Recommendation Report for Planning Permission for Works or Extension to a Dwelling

REF NO: M/145/21/HH

LOCATION: 44 Southdean Drive
Middleton-On-Sea
PO22 7TB

PROPOSAL: Roof extension to facilitate conversion of loft to habitable use and alterations to fenestration.

PROPOSED PLANS & ELEVATIONS

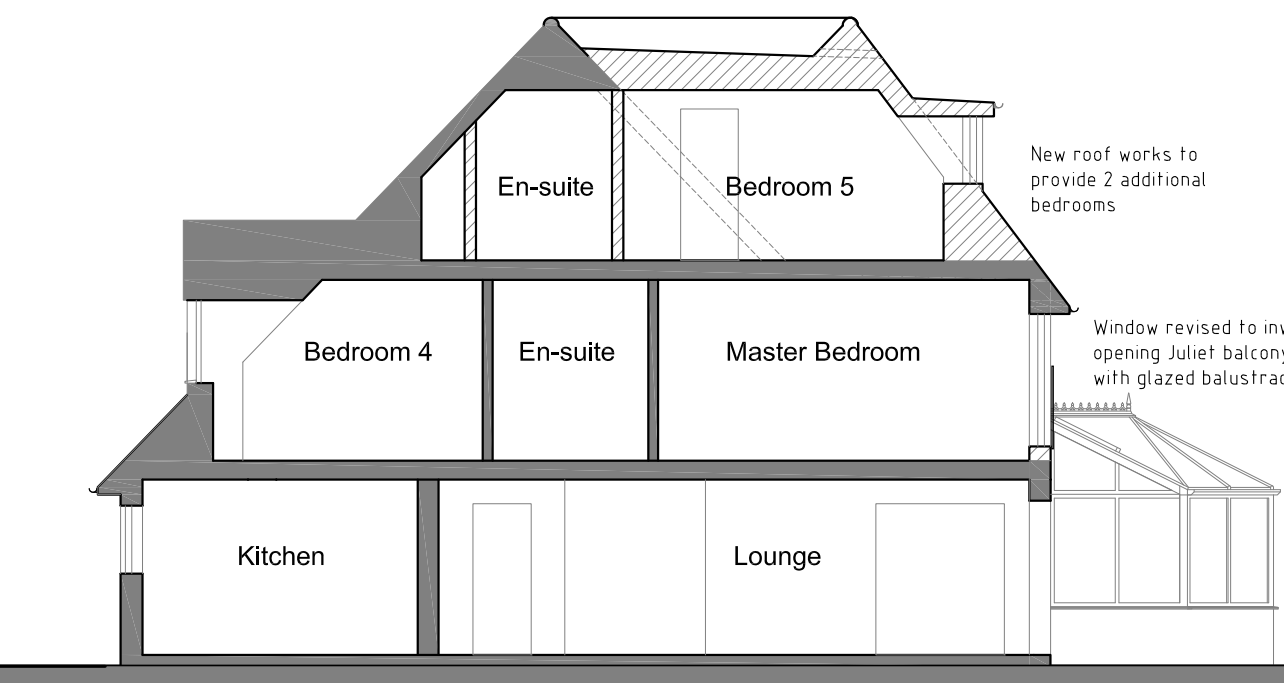
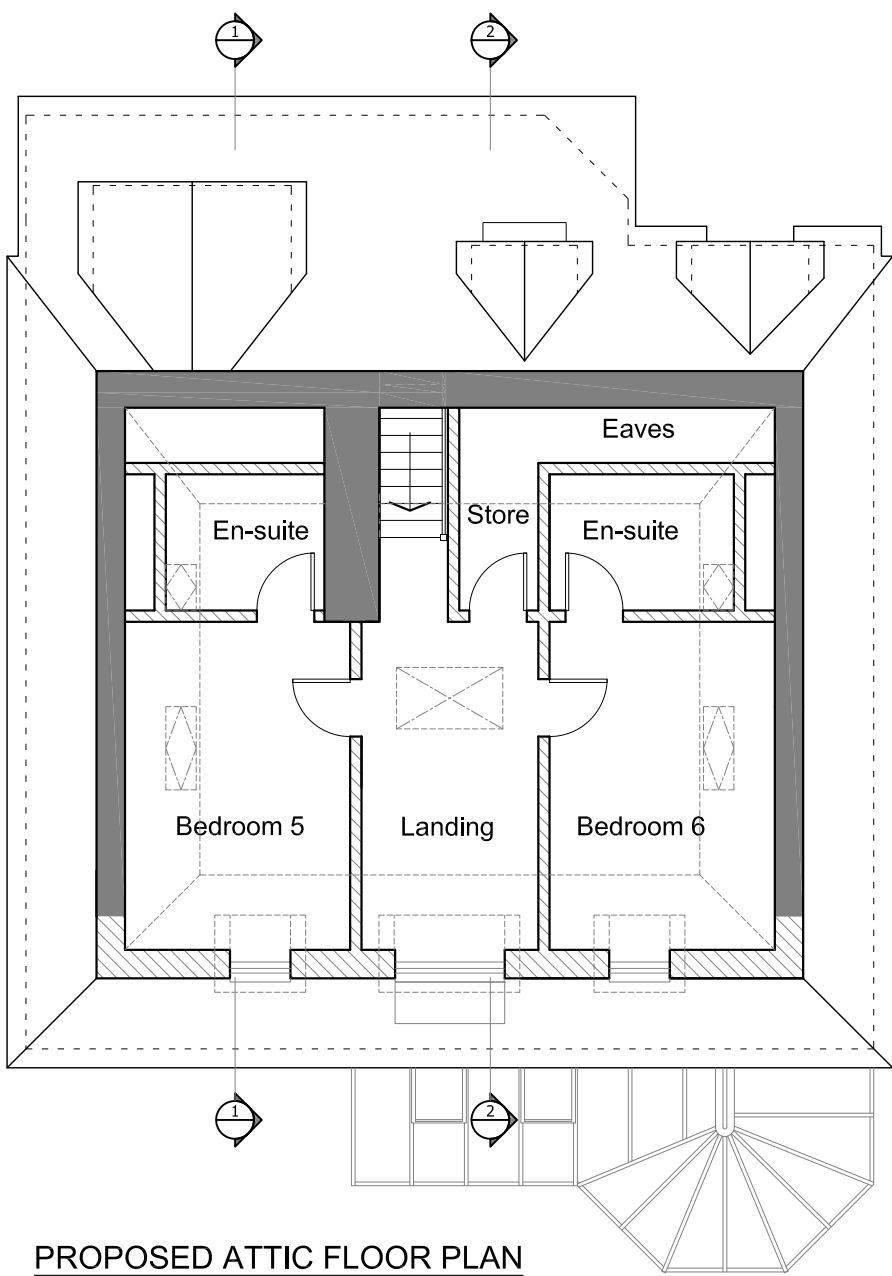
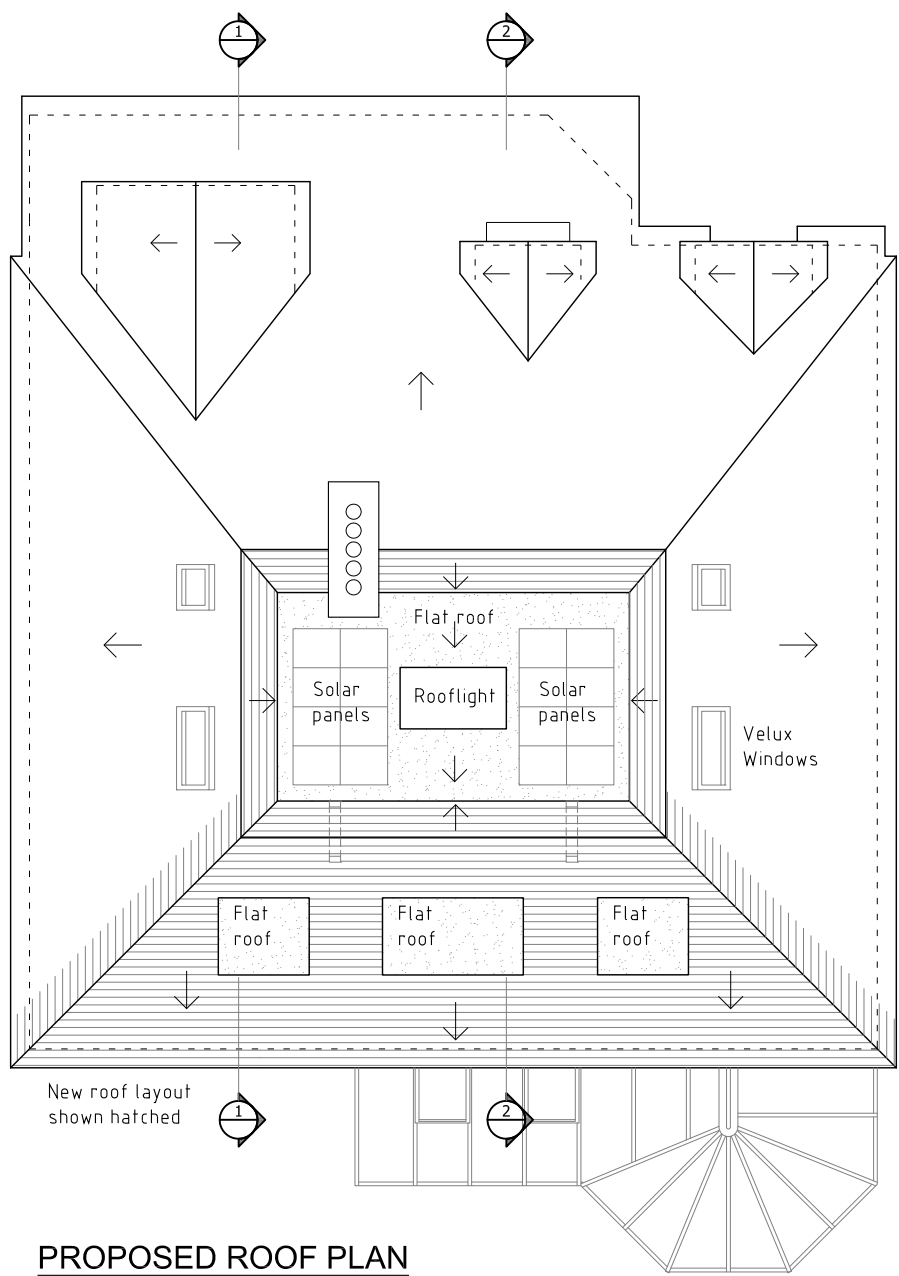
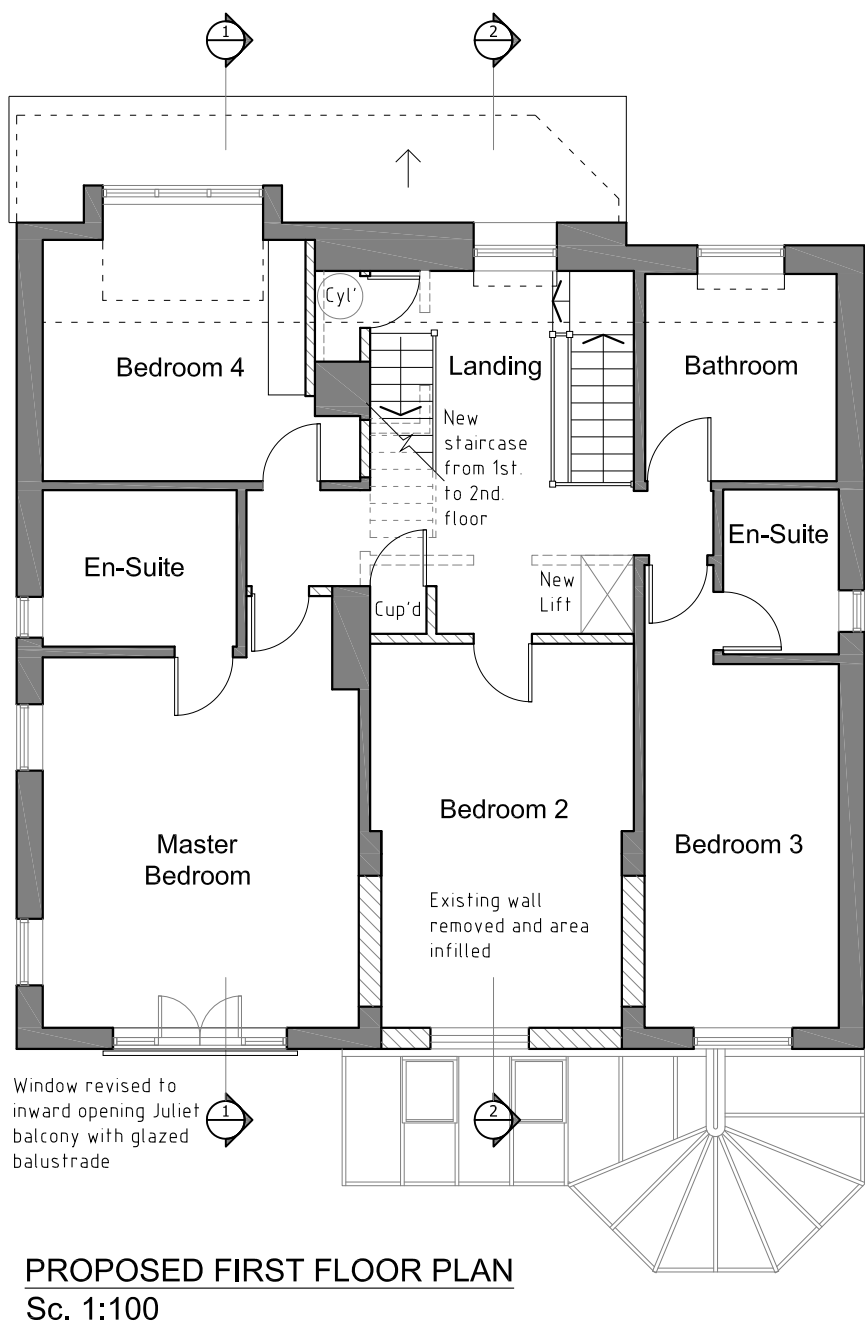
The property, a large family dwelling is set on a generous plot at the head of Southdean Drive. The property has neighbours to the west and east but backs onto the seafront. It is proposed to alter the configuration of the roof and add three roof dormers to the rear (southern) elevation of the property, add 4 rooflights to the east and west facing elevations and infill an area on the first floor to increase the size of Bedroom 2. No additional ground floor area is sought through this application.

The addition to the roof structure, will not increase the height nor extend past the existing most southerly roof plane. It is proposed to add a section of roof to join the southern plans of two existing hipped gables and enclose the infill extension on the first floor.

The rear facing dormers, the largest of which measures approximately 1.8m in width, are appropriately sized with glazing features to match the property's existing windows. Their proportionate scale infers good visual integration and subservience with the host dwelling.

This application does not propose additional increase in ground floor footprint. The first floor addition is an infill extension located between two existing protrusions and will not be overbearing or overshadow any neighbouring properties.

In terms of overlooking, the proposed dormer windows and increase in depth of an existing first floor bedroom window facing south will only achieve views already available by the occupants of the property, they will not increase overlooking into neighbouring properties.

The side facing roof velux windows appear to be located at a high level, however in order to control these they will be conditioned to be obscure glazed and fixed shut below 1.7m above finished floor level.

- 3 The rooflight windows hereby approved to the east and west elevations shall be non-opening and fully obscured below, 1.7m above finished floor level prior to the first use of the rooms. The windows shall be retained as obscure glazed/non-openable in perpetuity.
